From: Contact Centre (CRM) <contact@ribblevalley.gov.uk>
Sent: 29 September 2024 18:19
To: Planning
Subject: Planning Application Comments - 3/2024/0678 FS-Case-650665518

Planning Application Reference No.: 3/2024/0678

Address of Development: 10 Manor Road, Whalley BB7 9TE

2
PROPOSED SITE PLAN
1 : 200

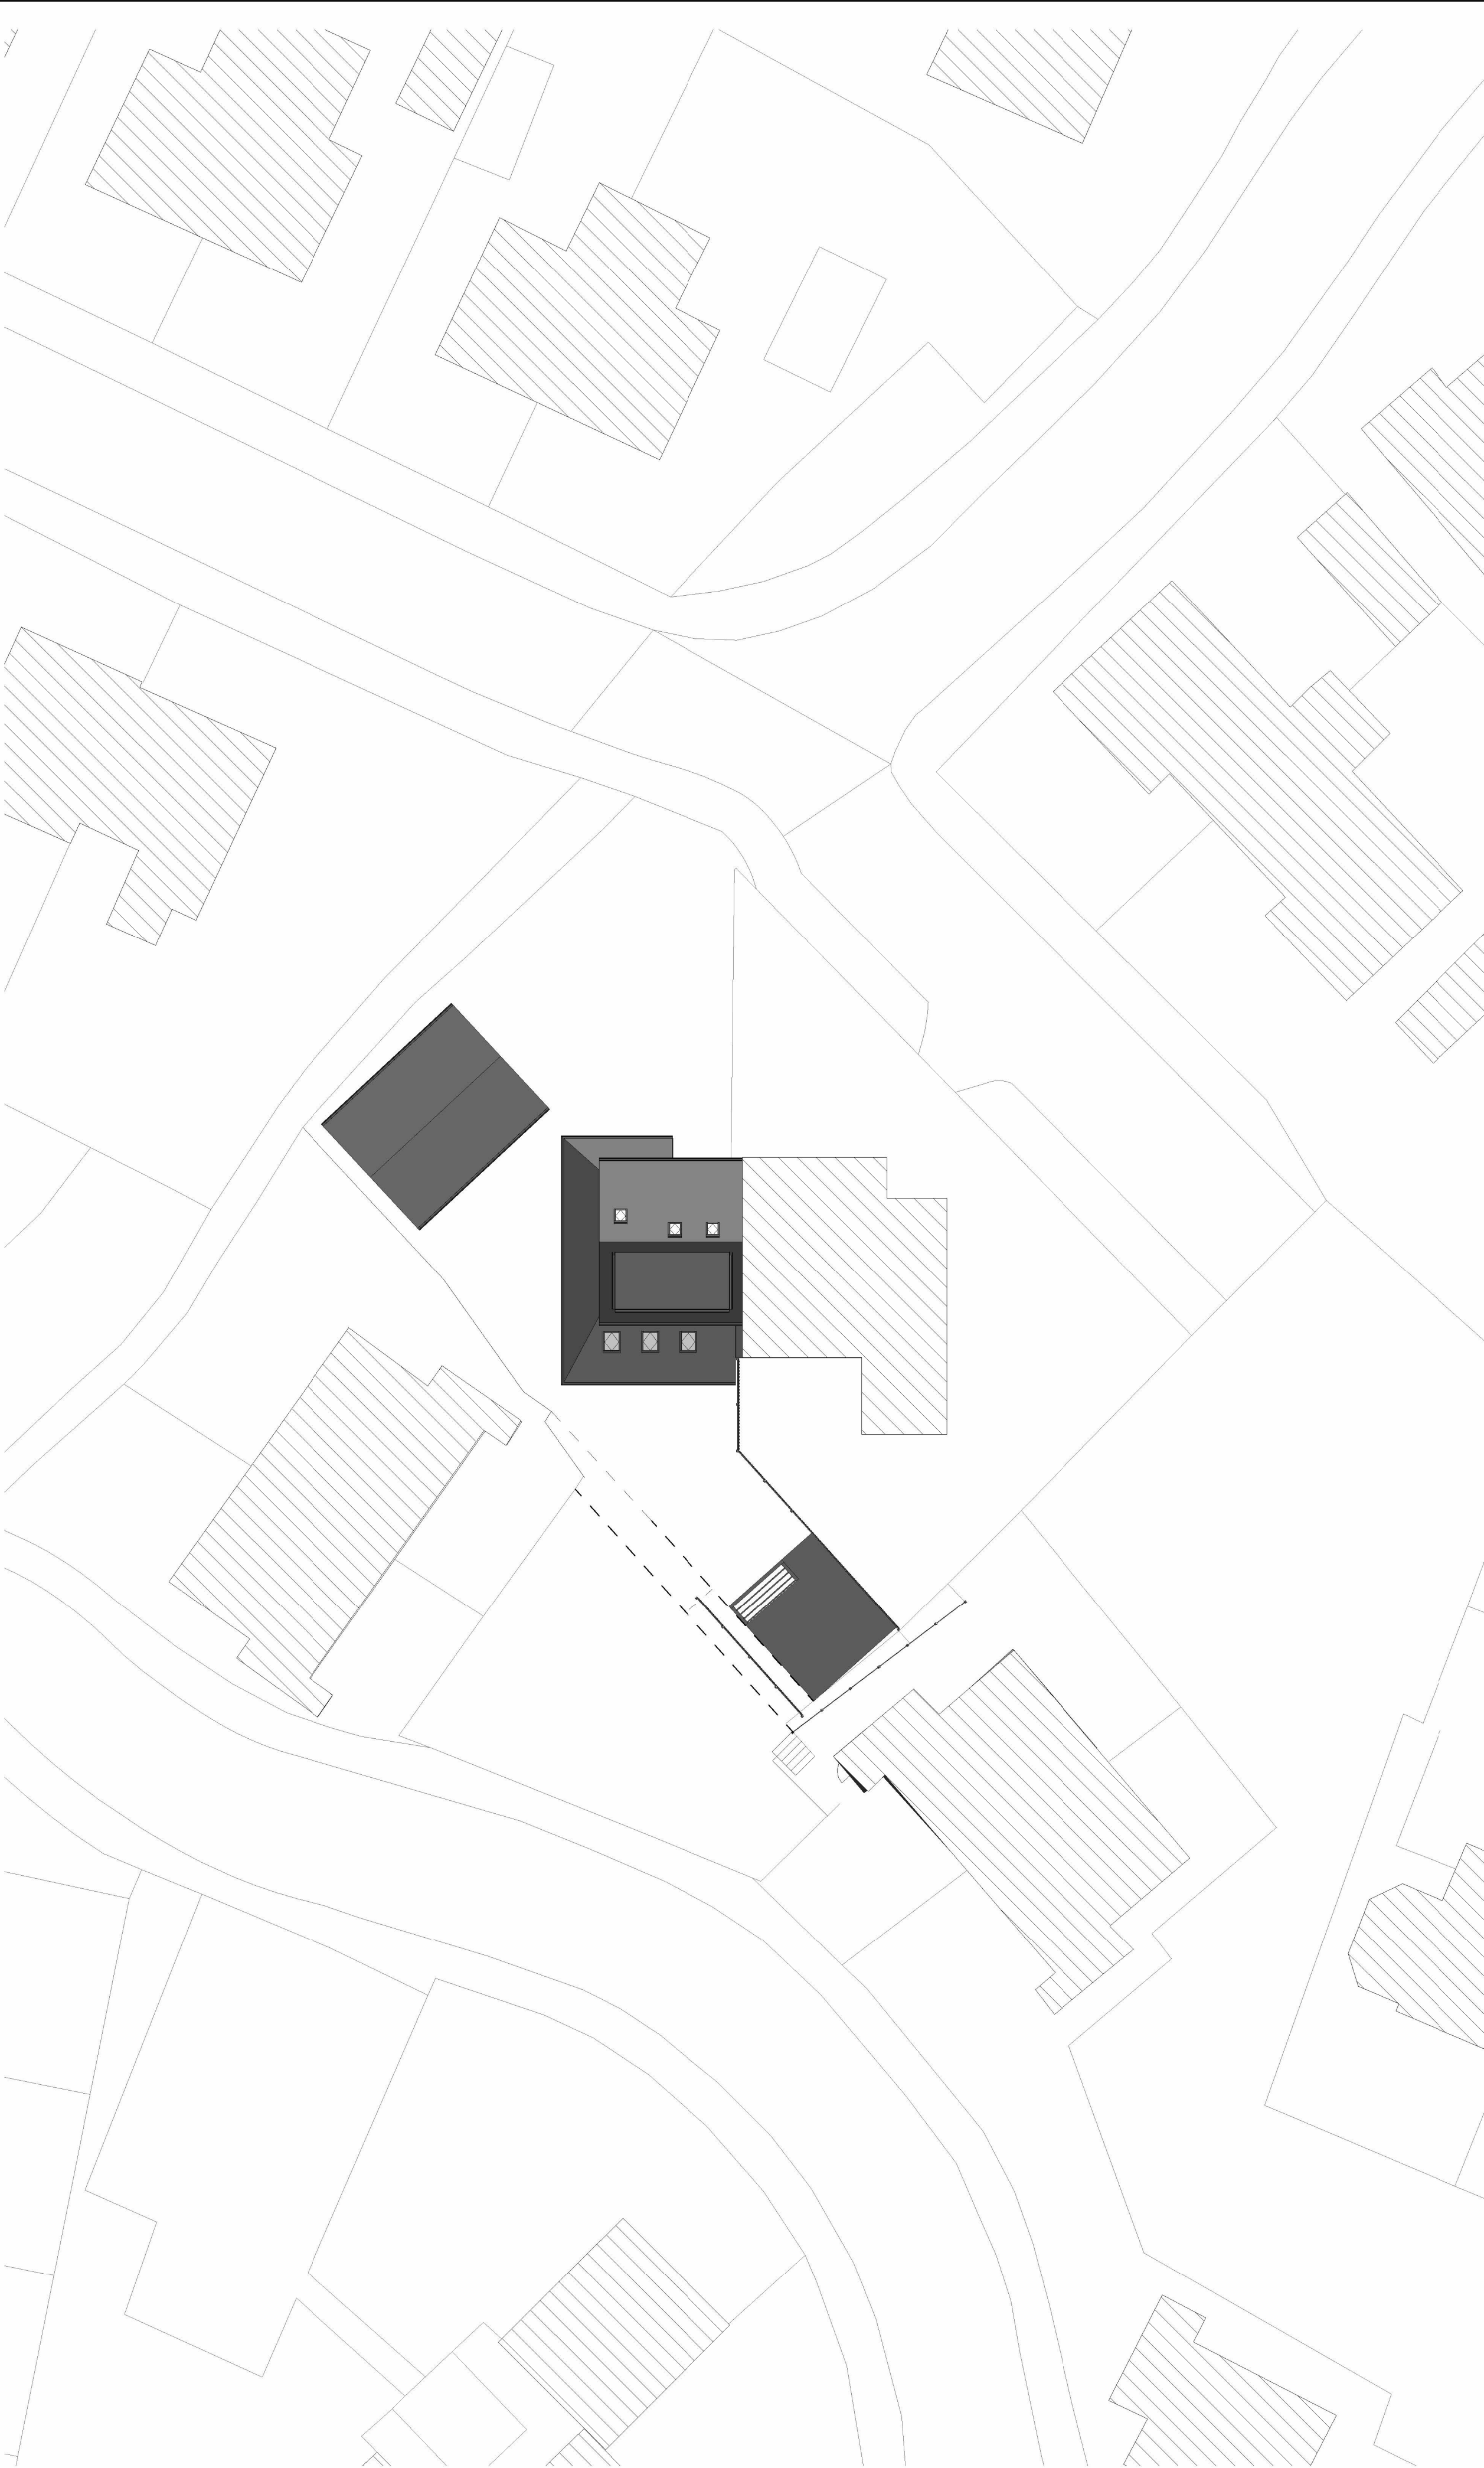
3) Not sure what is meant when it mentions the "foundation design to respect the site boundary line", because the proposed development will extend lower than the existing fence post and therefore the fence along the boundary line will be affected by the same. While not clear from the drawings if a new fence is being proposed as part of the development, [REDACTED]
[REDACTED] ;
